APPEAL STATEMENT

Planning Inspectorate Reference:	APP/T2350/W/22/3304318
LPA Application Reference:	3/2022/0144

Against the refusal by Ribble Valley Borough Council to grant planning permission for:
Proposed erection of a random stone single residential dwelling within the rear curtilage of Pimlico House. Land to the rear of Pimlico House Gisburn Road Gisburn BB7 4ES

North elevation

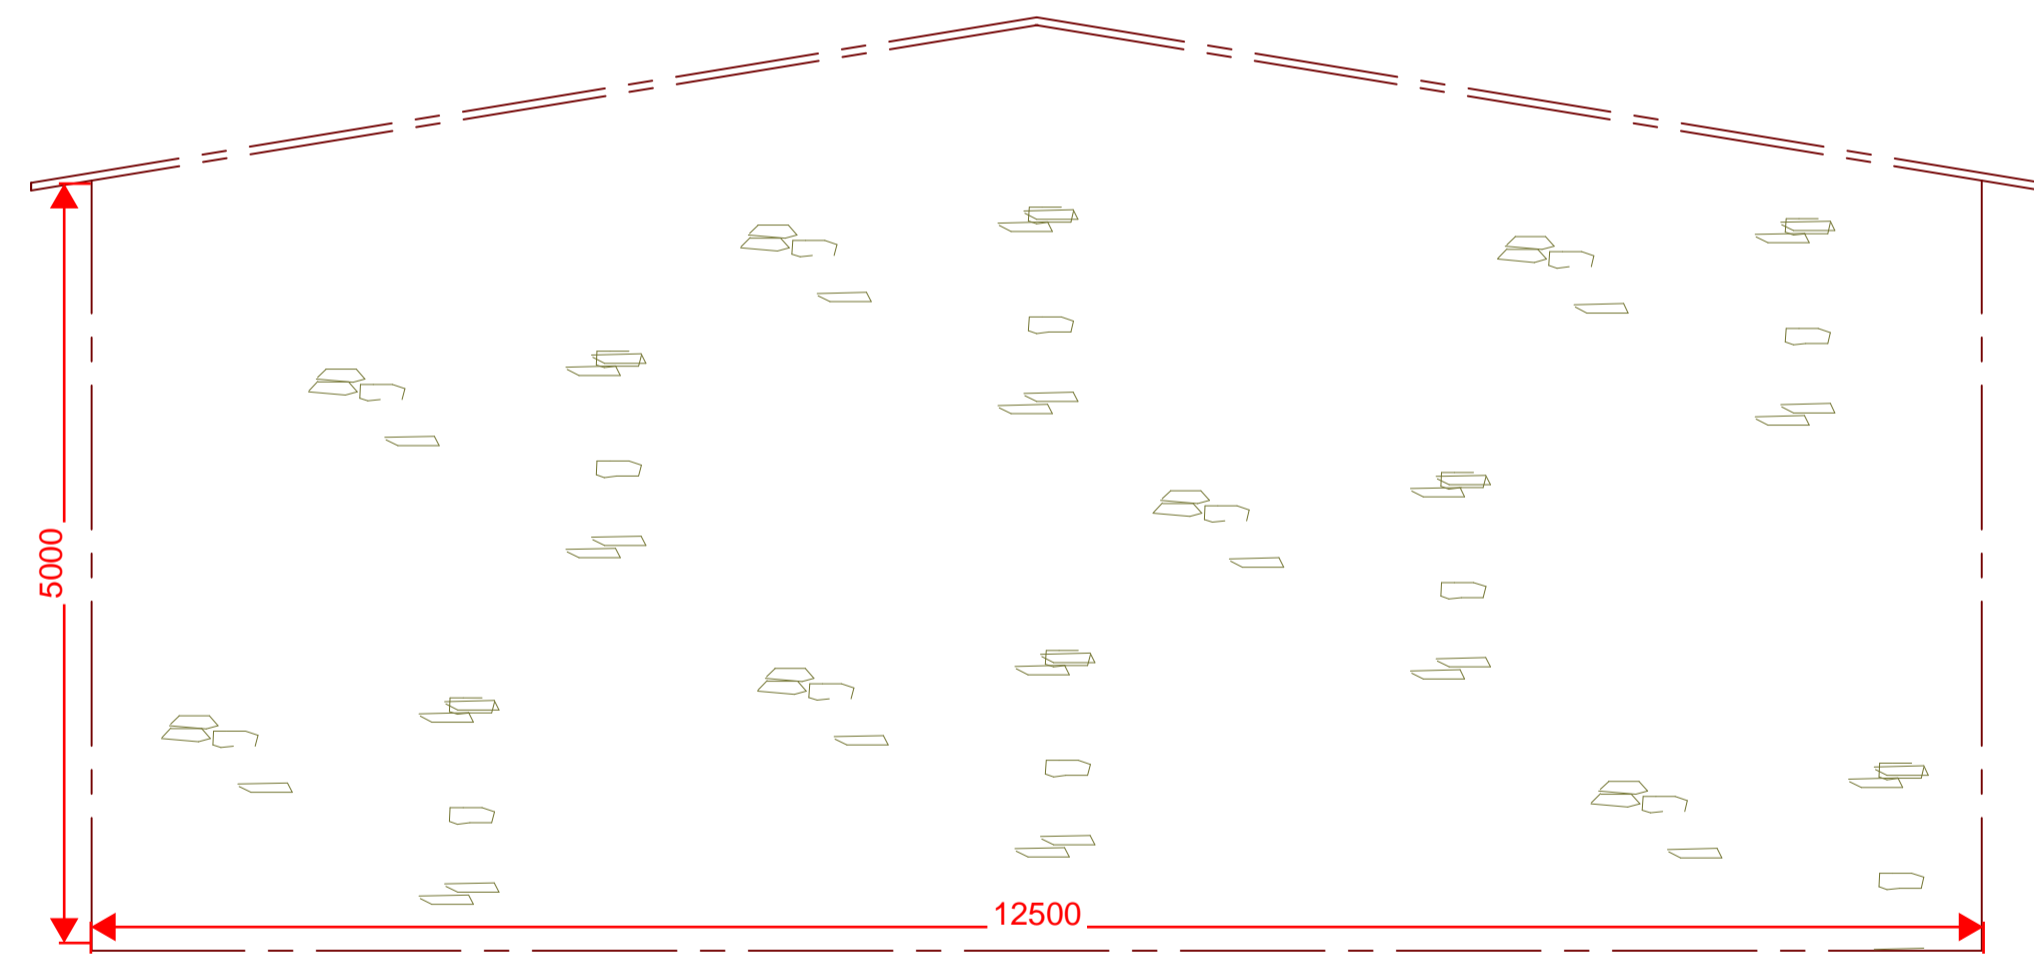
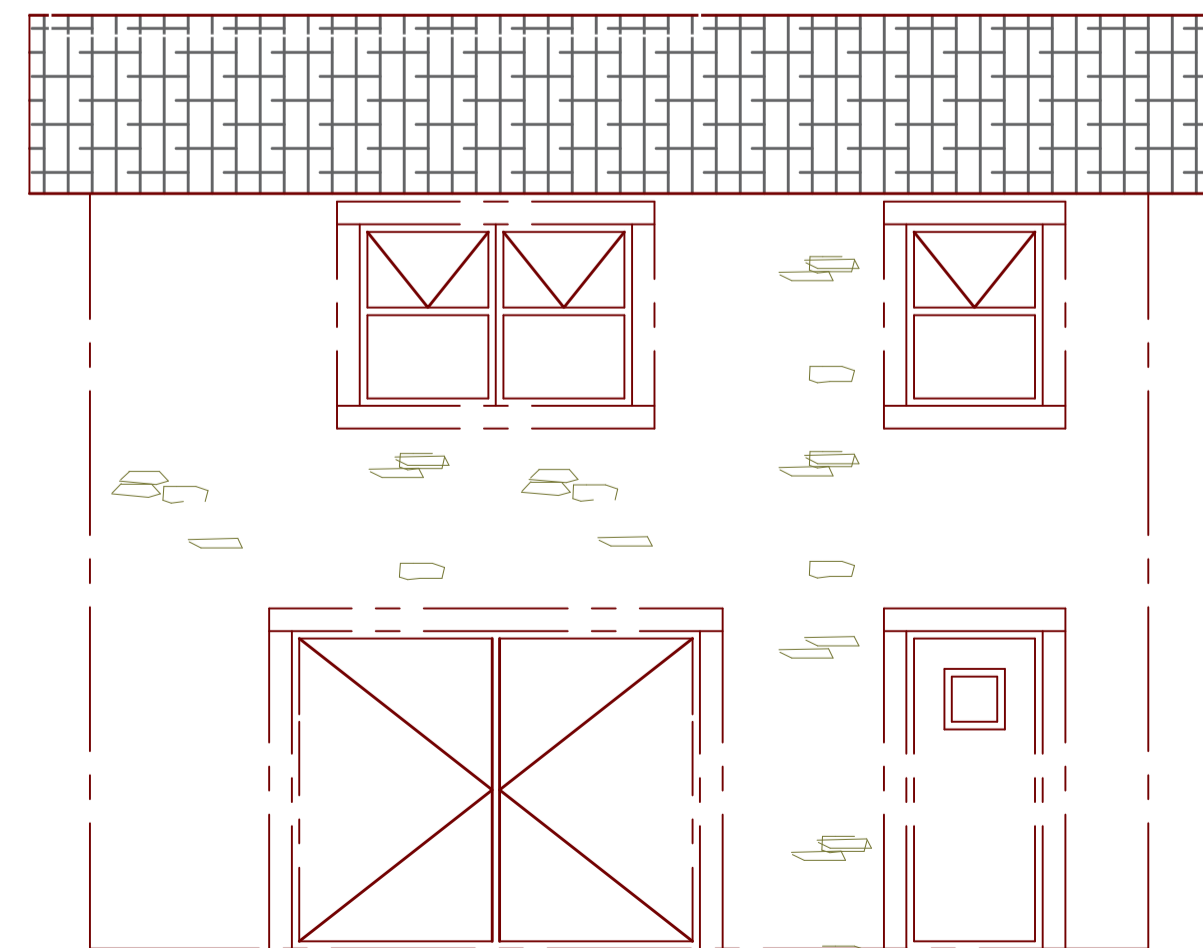
- 7.8 The exaggerated roof overhangs proposed on the side elevations (north and south) would only exacerbate the discordant appearance of this element which would also appear at odds with the surrounding roofscape which is largely defined by eaves that terminate tile-to-verge.

South elevation

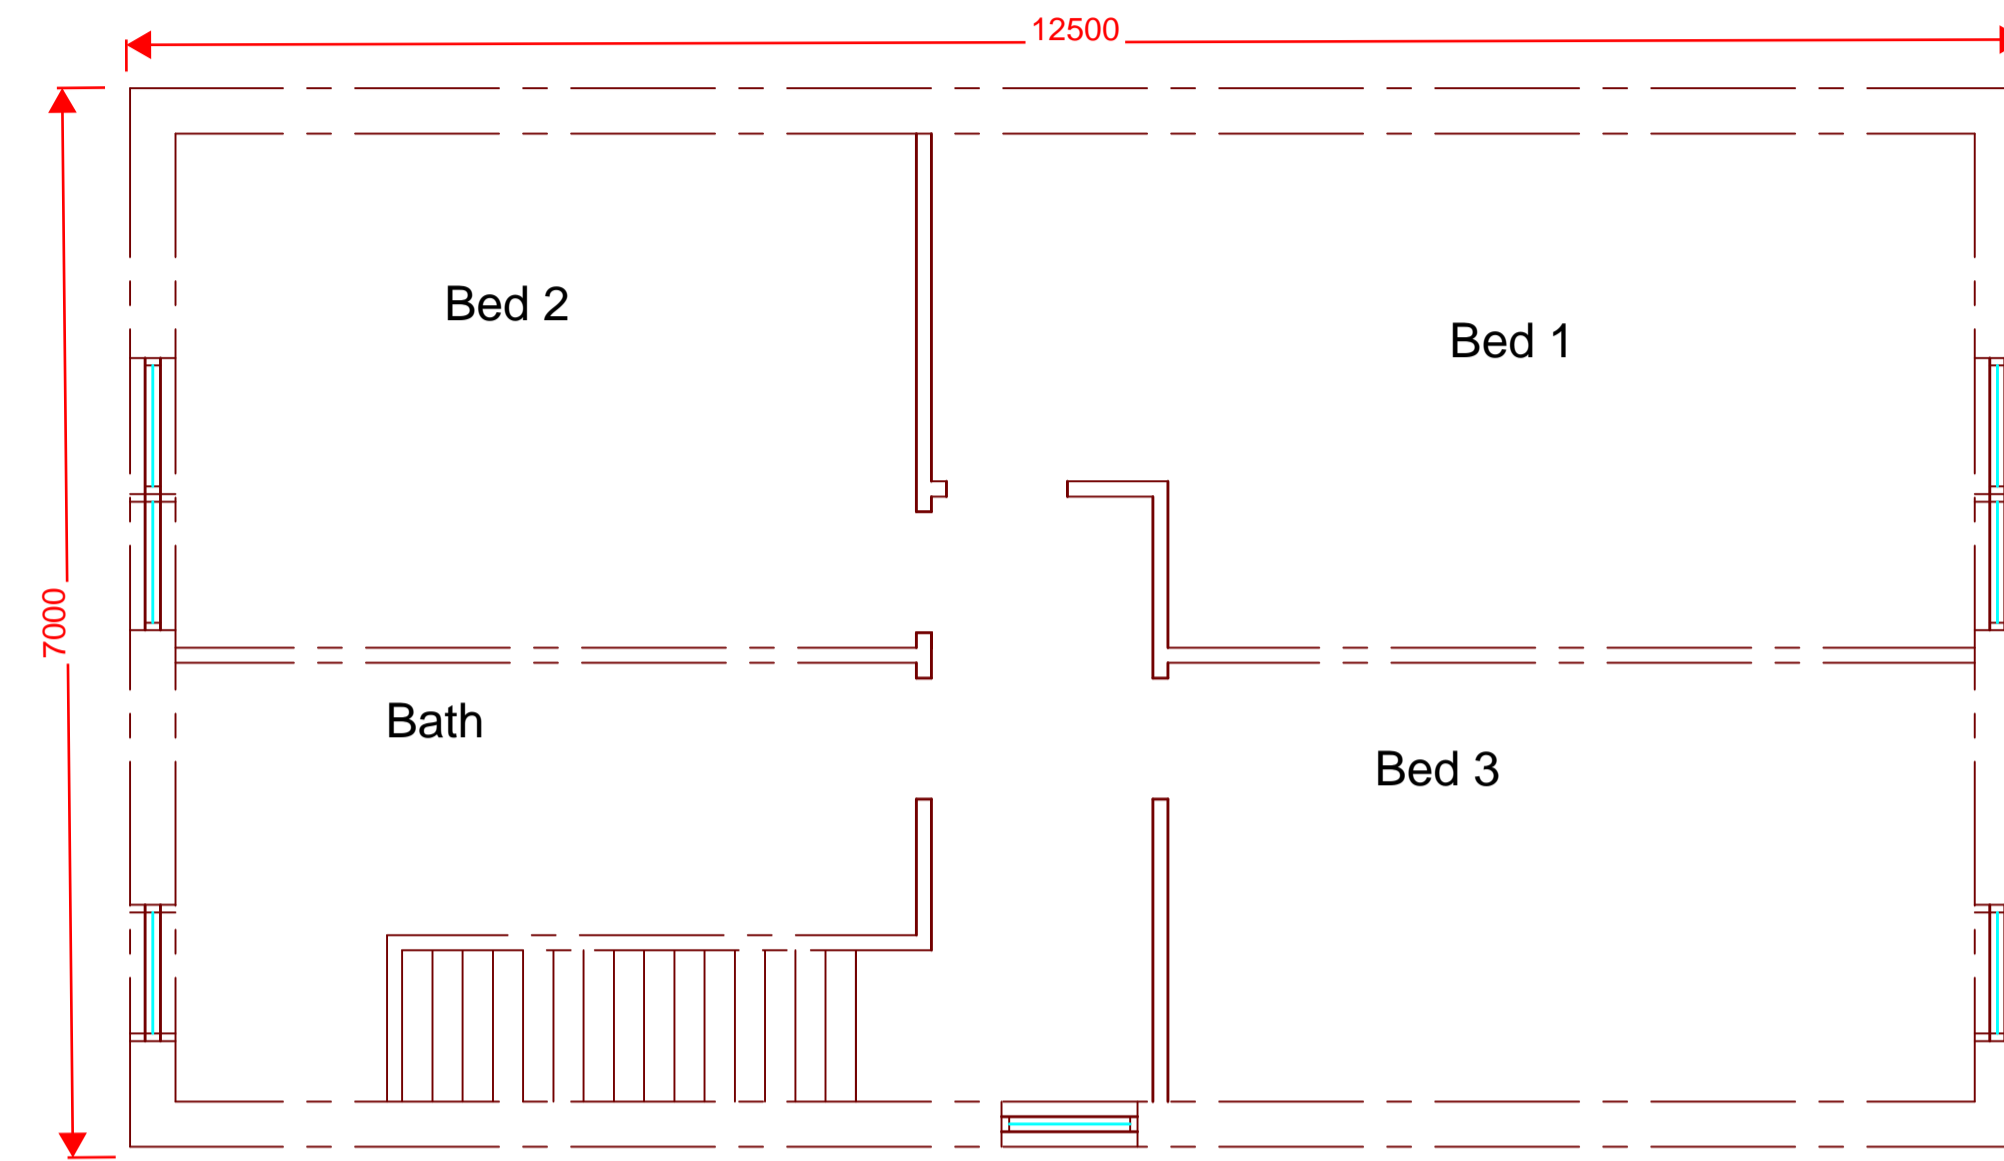
- 7.6 Further anomalies are present on the south elevation which appears to show a centrally located door, which when taking account of the proposed site-plan, would open on to an area of land that appears to be outside the extents of the application site and potentially the applicants ownership.

- 7.11 The south elevation of the proposed dwelling will also be afforded a high level of visibility upon approach from the south, in this respect, taking account of the overtly horizontal proportioning of the side elevation, in concert with the shallow roof-pitch, will result in the dwelling appearing both visually 'squat' disproportionate in relation to nearby residential built-form.

Front (west) elevation

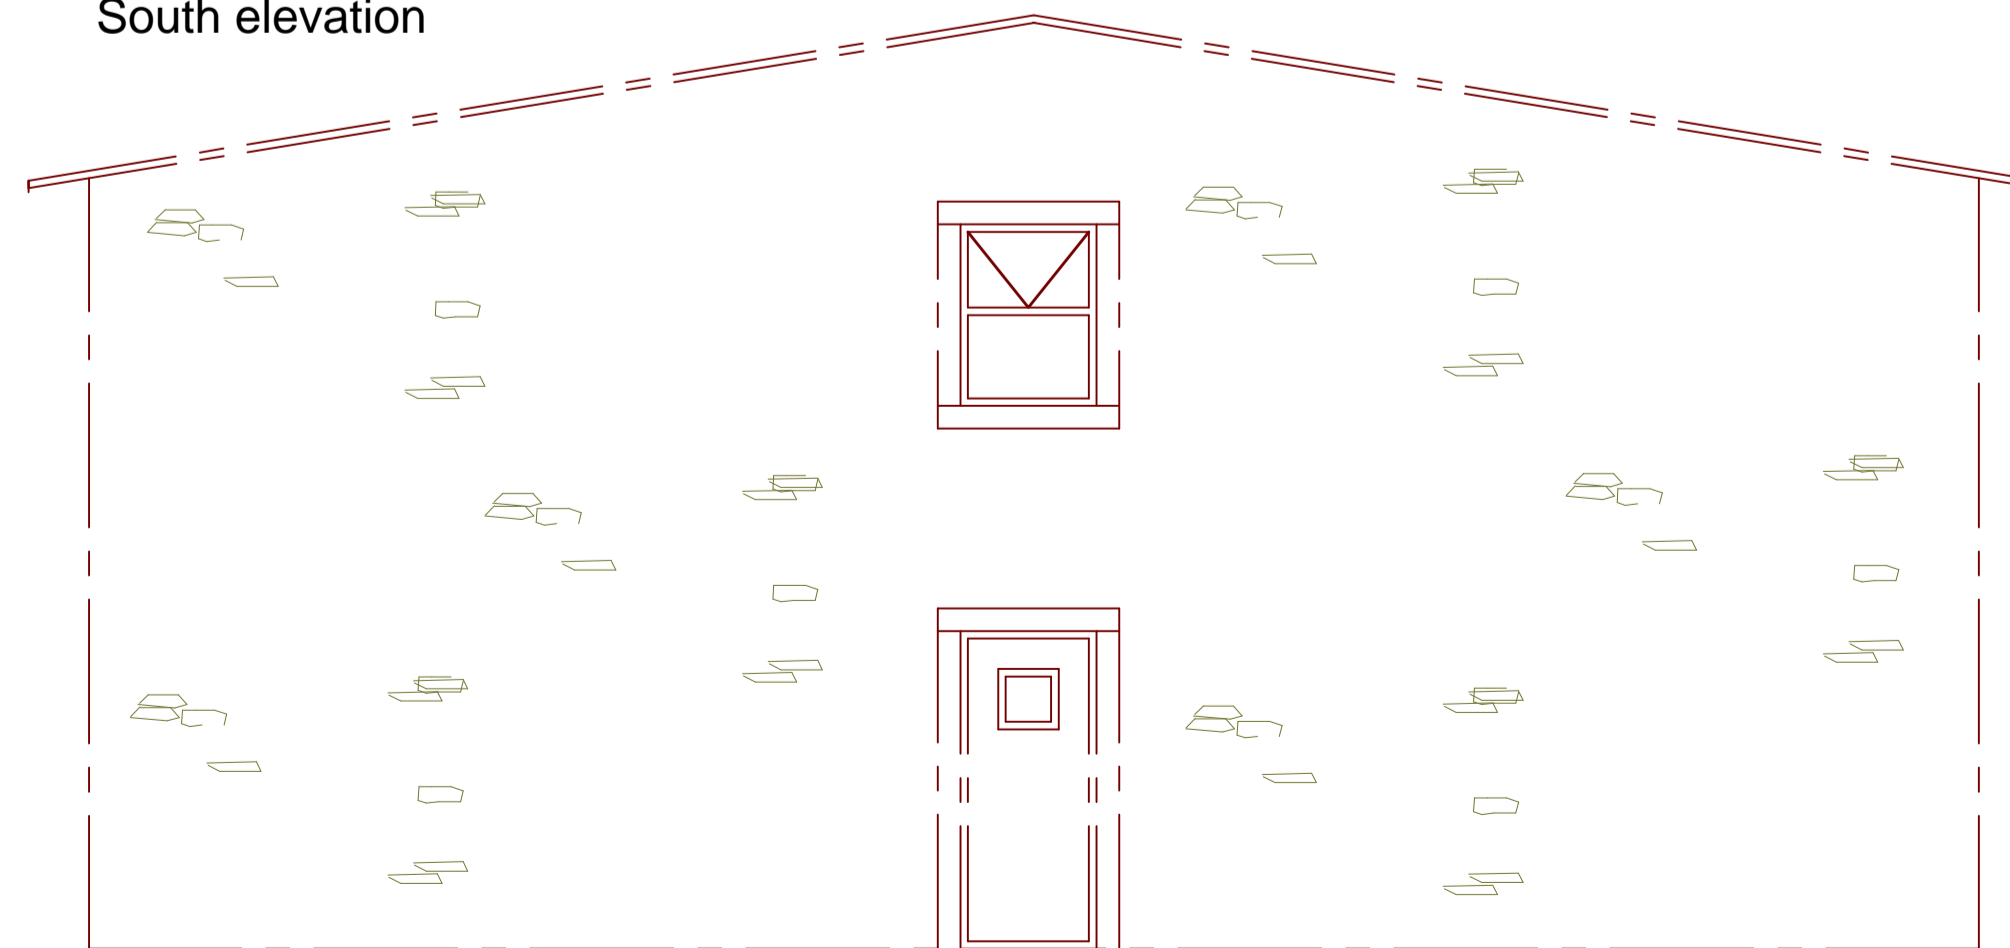
- 7.5 It is respectfully requested that the Inspector note that the submitted details contain a number of significant inconsistencies in that the proposed floorplans fails to correspond to that of the proposed elevations. The front elevation appears to be a 'mirror' of the proposed floorplan and a such fails to correspond. Additionally, the rear elevational details show one single door opening and an opening for what is assumed to be a double bi-fold door arrangement; however, the corresponding floorplan only shows a singular opening.

- 7.9 The overall proportioning and detailing of the elevations, in particular the front elevation, fails to benefit from a clear visual ordering or hierarchy - with the openings on this elevation appearing visually skewed towards the northern extents of the building resulting in a somewhat unbalanced appearance of the primary elevation fronting the streetscene.
